BEFORE THE HEARING EXAMINER OF THE CITY OF MERCER ISLAND

IN RE: NOTICE OF DECISION: FILE NO.
2207-019

Case No. APL24-002

APPELLANT DANIEL GROVE'S
CORRECTED PRE-HEARING
MEMORANDUM AND RESPONSE TO
DOROTHY STRAND AND THE CITY
OF MERCER ISLAND'S REQUEST
FOR DISMISSAL

WEST ELEVATION

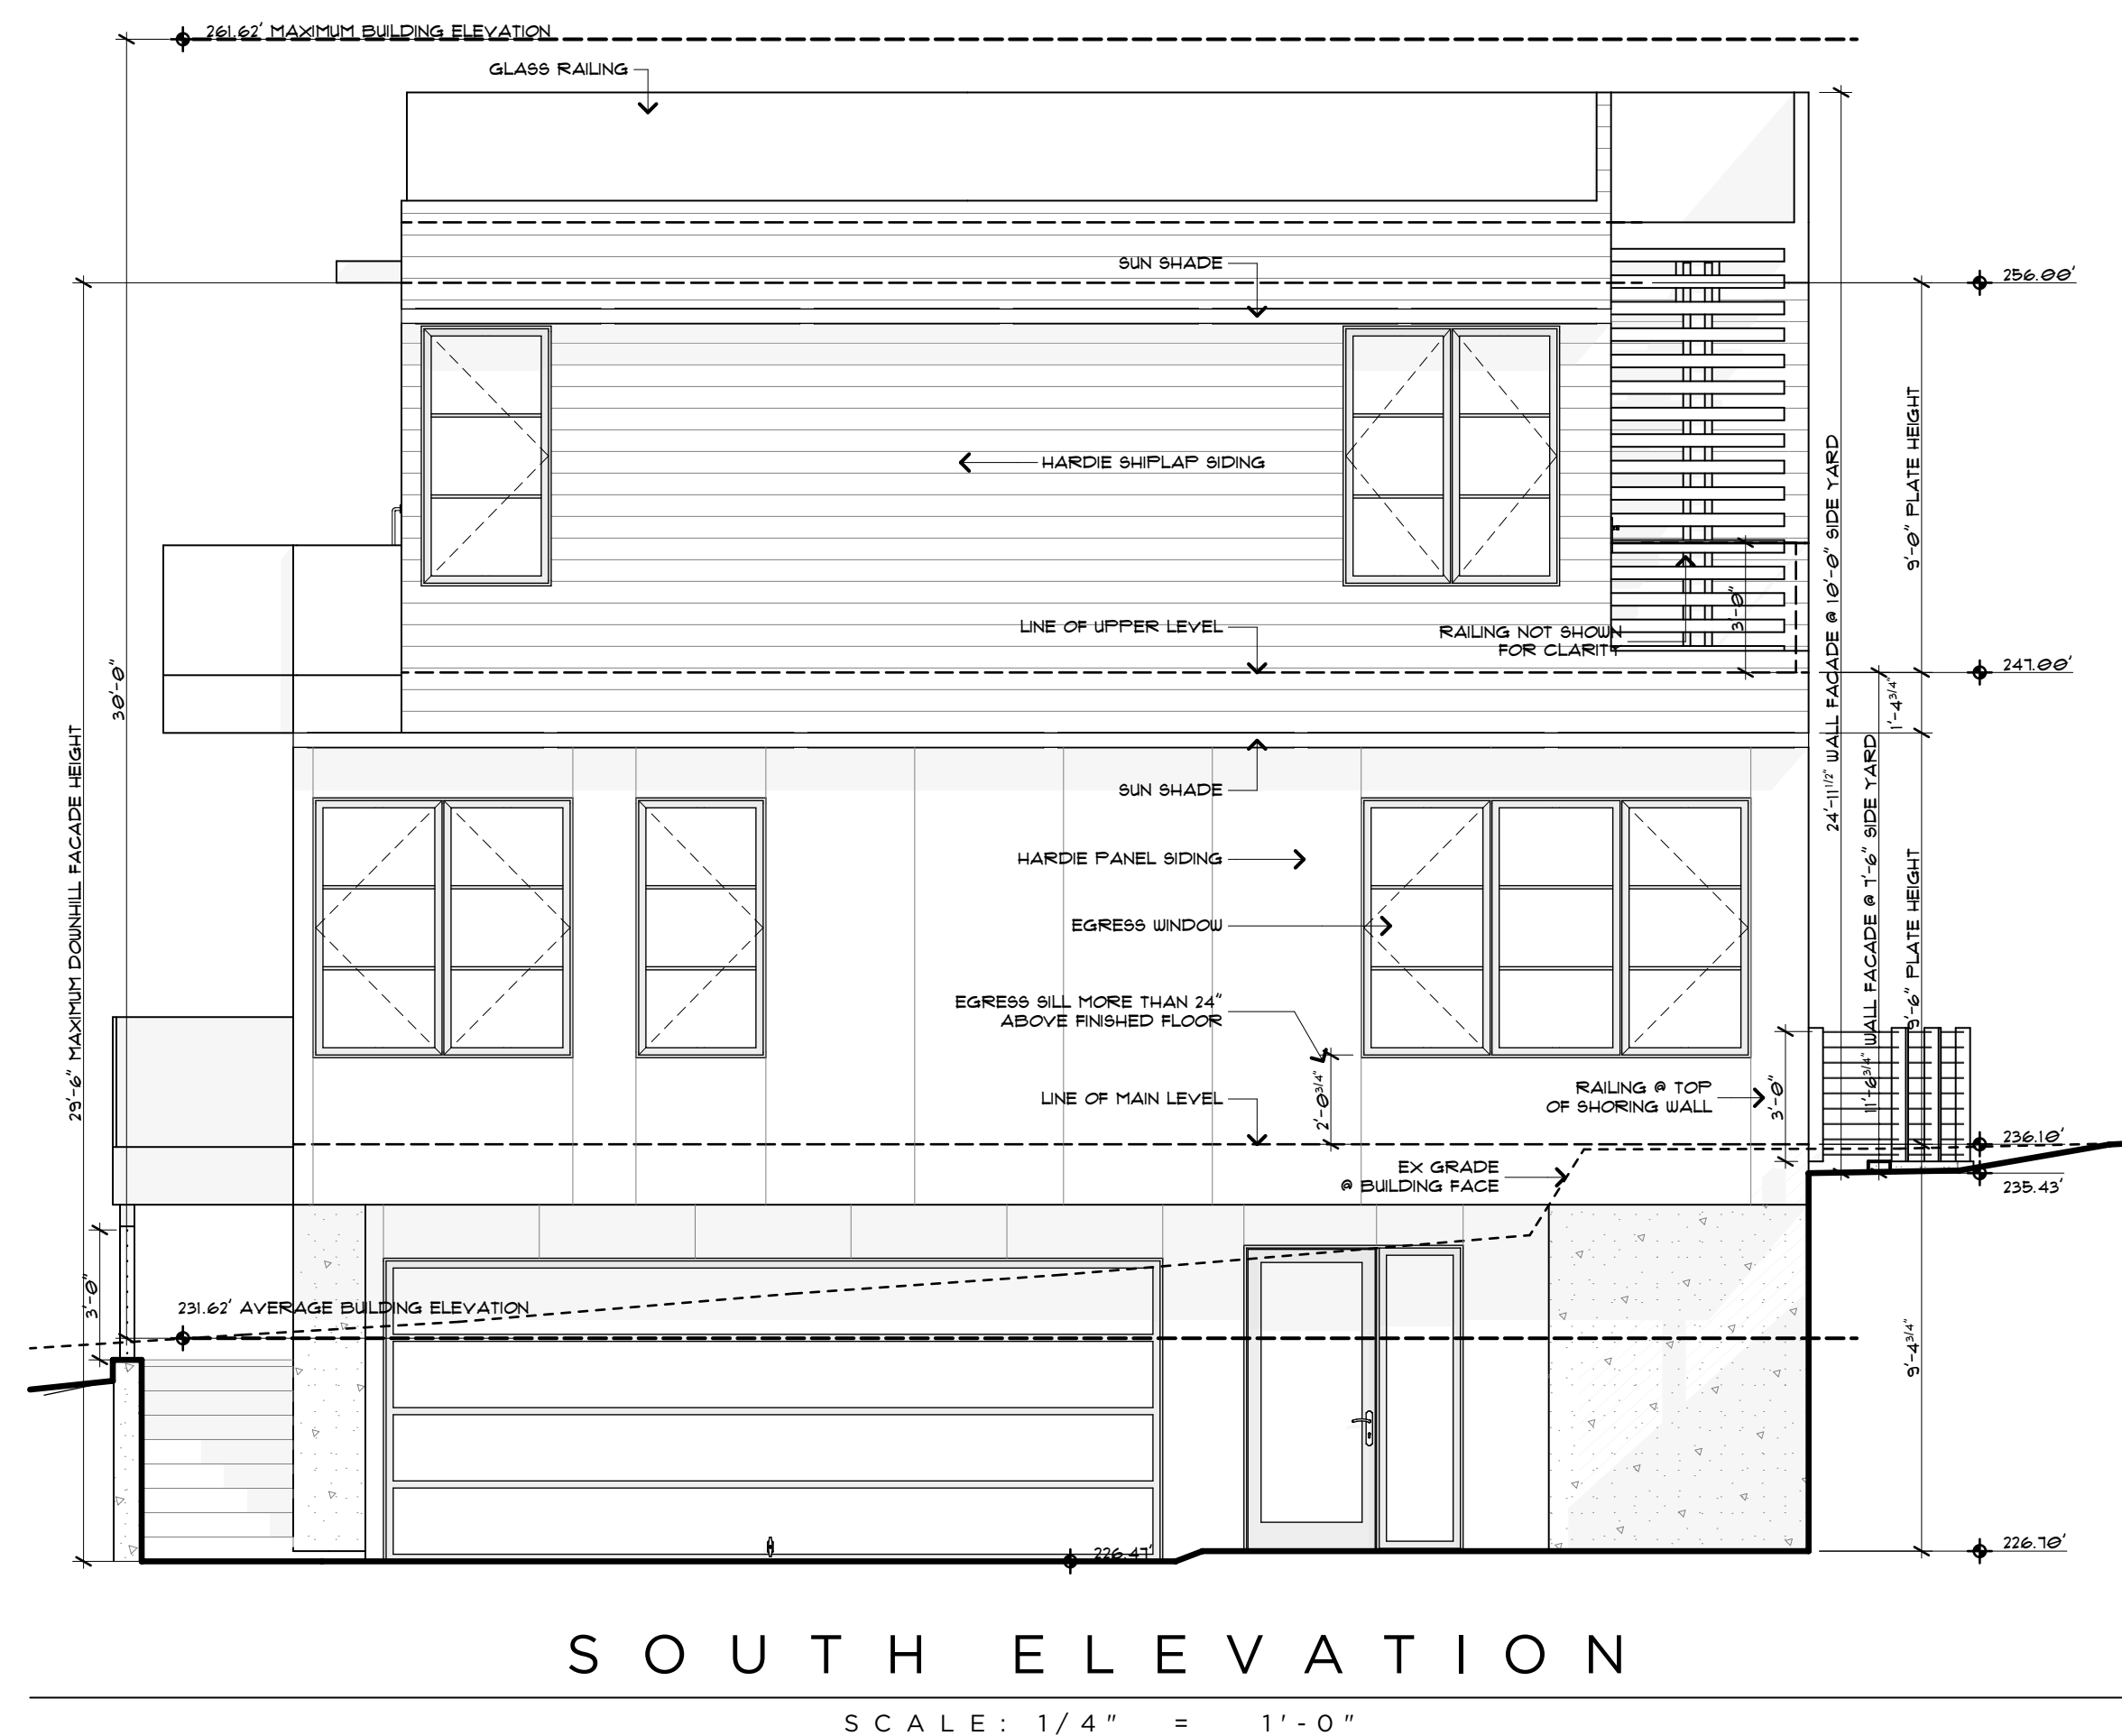
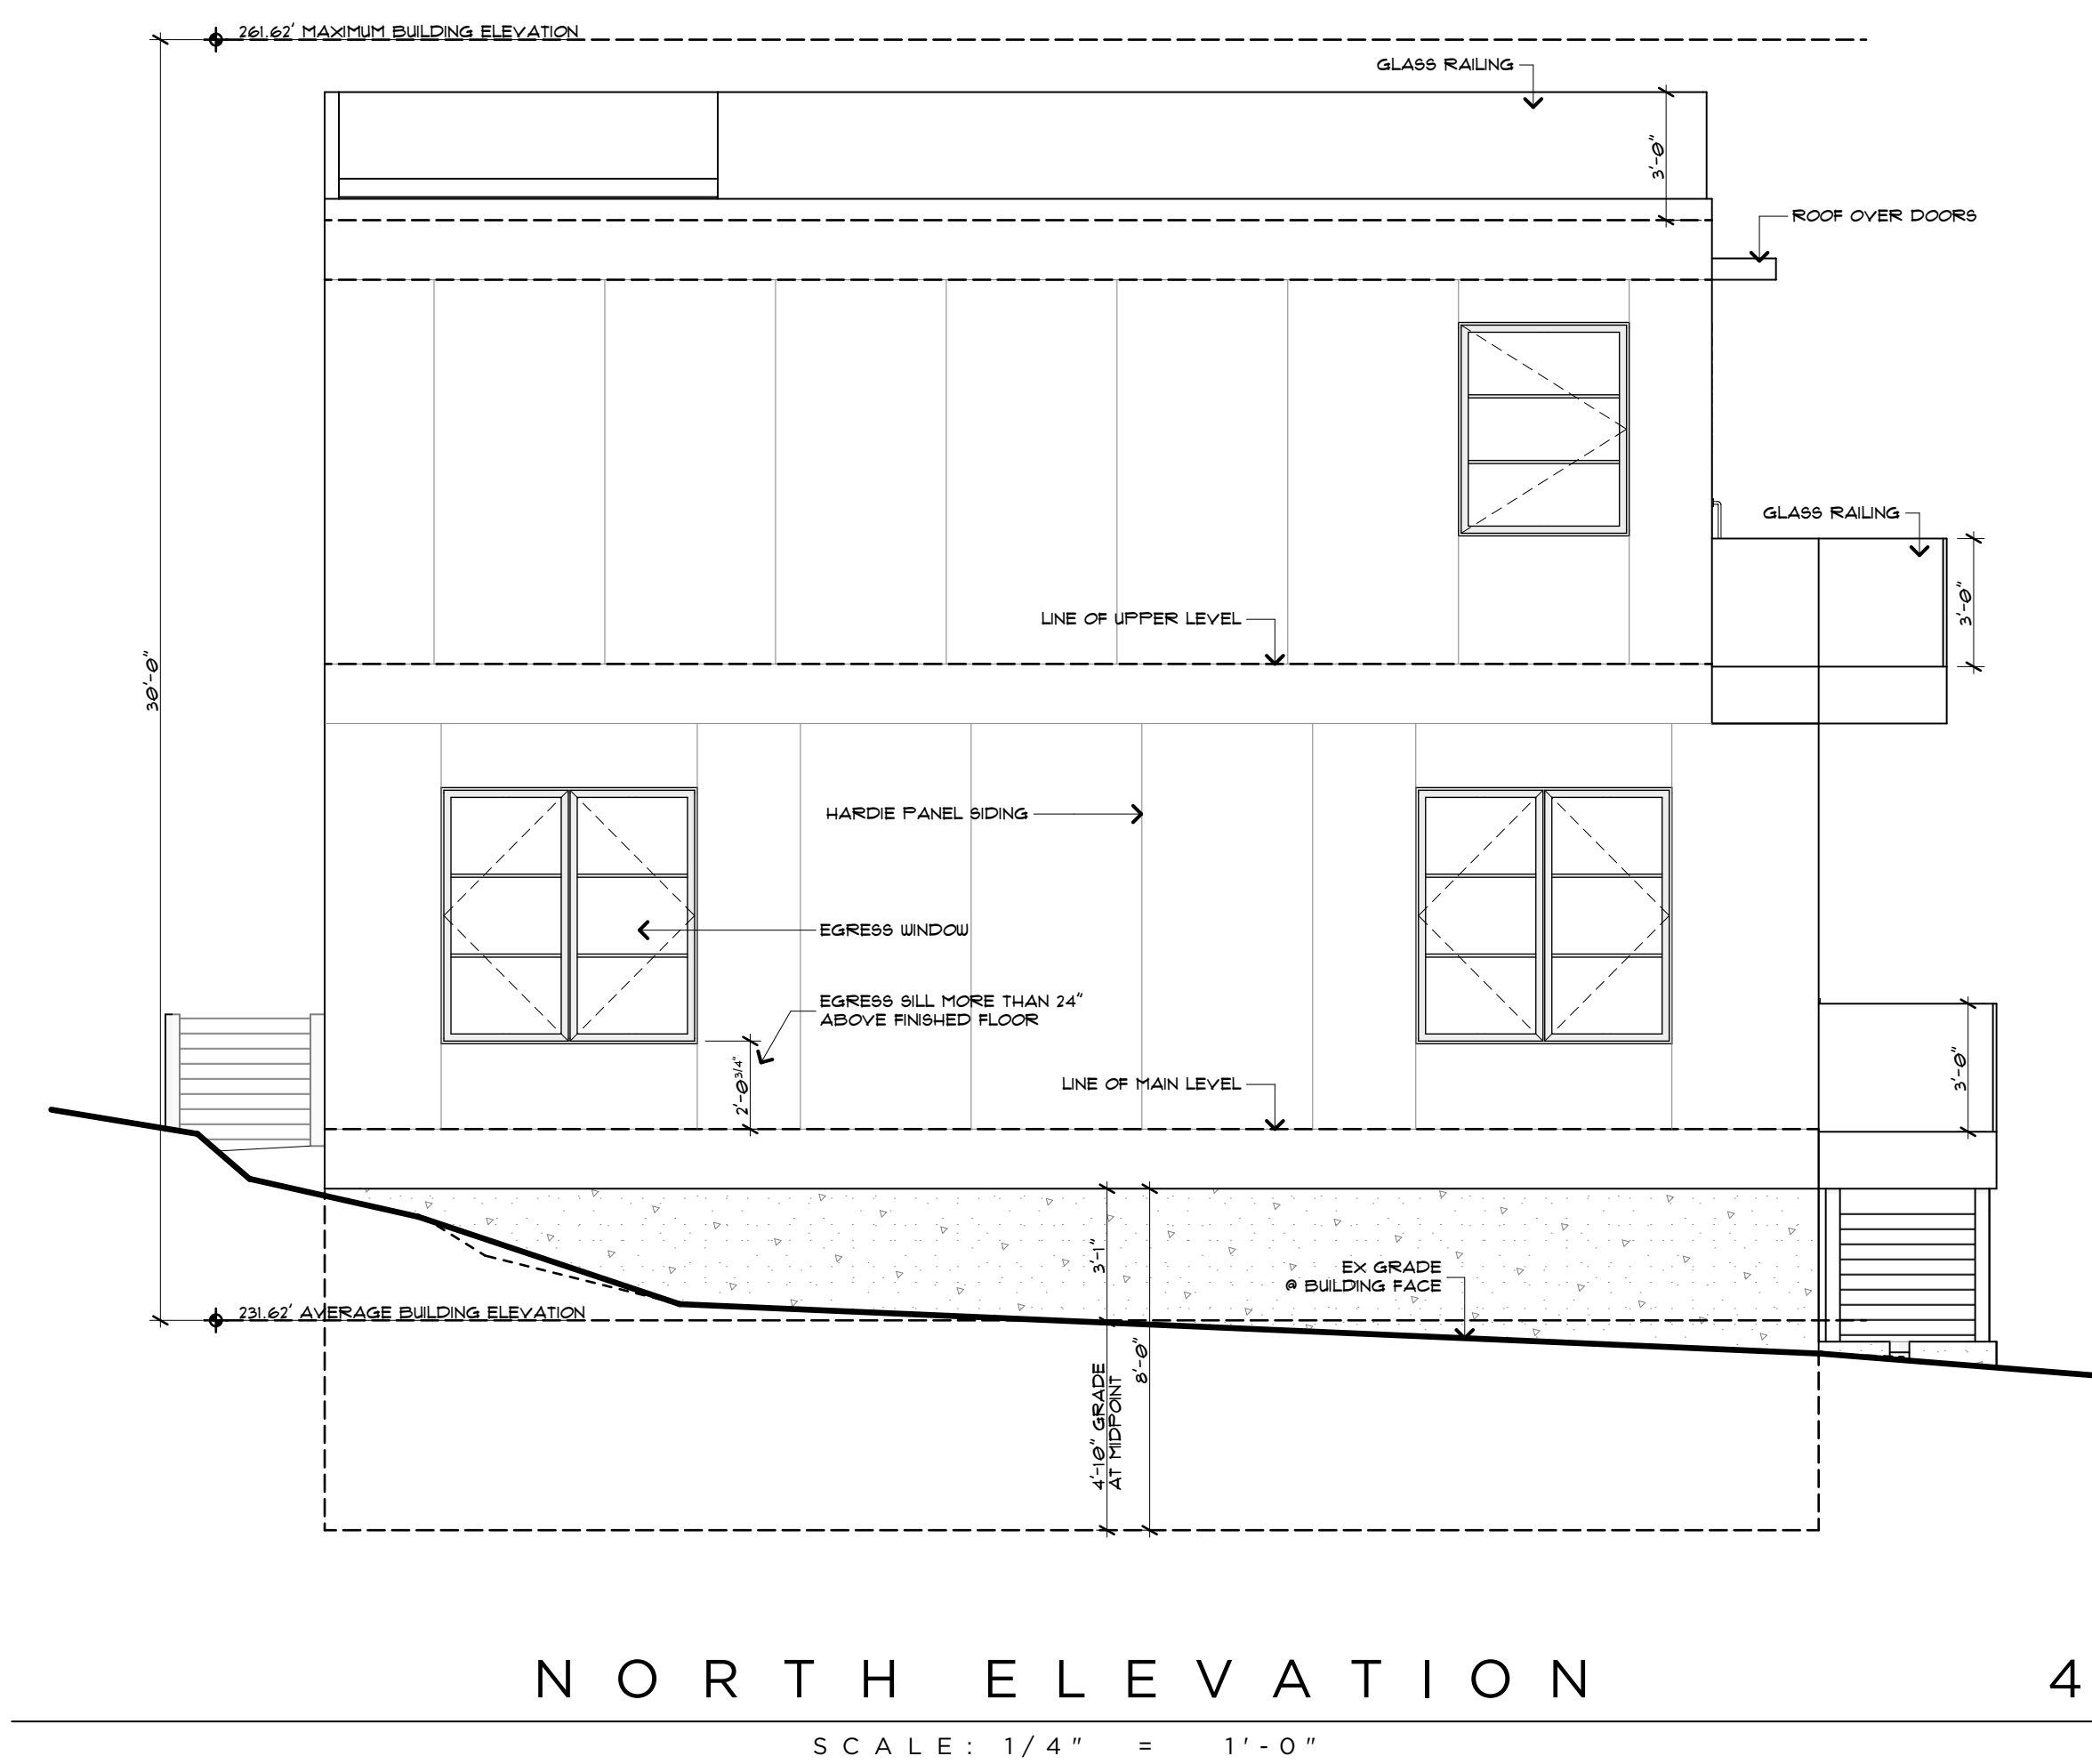
1 *whichever is lower, at the furthest downhill extent of the proposed*
2 *building*, to the top of the exterior wall facade supporting the roof
3 framing, rafters, trusses, etc.” Staff Report at 8. It is not disputed
4 that the property at issue in this case slopes downhill primarily from
5 east to west. The rooftop railings attached to the southern exterior
6 wall and the southern end of the western wall both exceed maximum
7 allowed heights.

8 Certain appurtenances may exceed that 30-foot height limit, but rooftop railings are not
9 one of them. MICC 19.02.020(E)(3)(b). *Id.* Ms. Strand appears to rely on a measurement from the
10 “Average Building Elevation” to determine a height of below 30 feet. *See* Strand Motion at 8. But
11 this is not consistent with the language of MICC 19.02.020.E., as explained above. The City
12 appears to rely on Ms. Strand’s inaccurate calculations to come to a similar conclusion that the
13 height has not been exceeded. Mr. Grove requests the Hearing Examiner review these
14 determinations and remand to the City for further consideration.
